Subject: FW: NRAR response - RE: Tilbuster solar farm SSD 9619 - revised layout of solar panels- EIS

Subject: NRAR response - RE: Tilbuster solar farm SSD 9619 - revised layout of solar panels- EIS

In response to P&A's email and the revised layout for the Tilbuster Solar Farm below NRAR's advice is as follows:

Figure 6 | Amended development footprint compared with the EIS development footprint

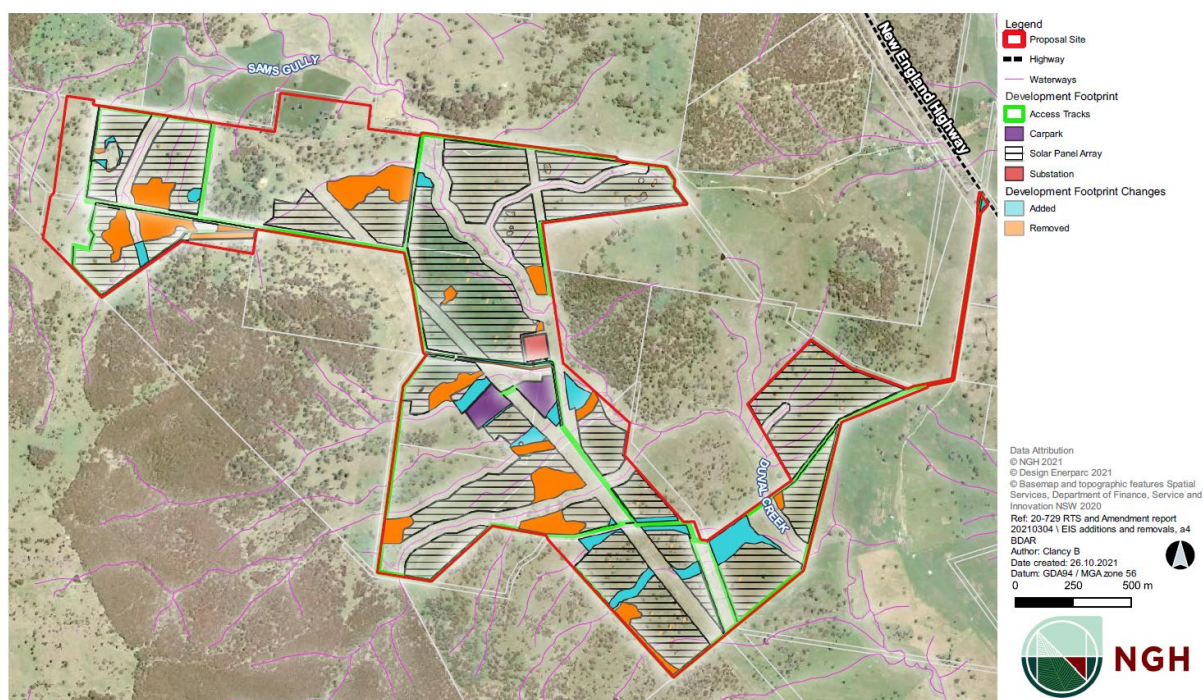
- The revised layout which reduces the extent of solar panels in some vegetated areas raises no concerns for NRAR.
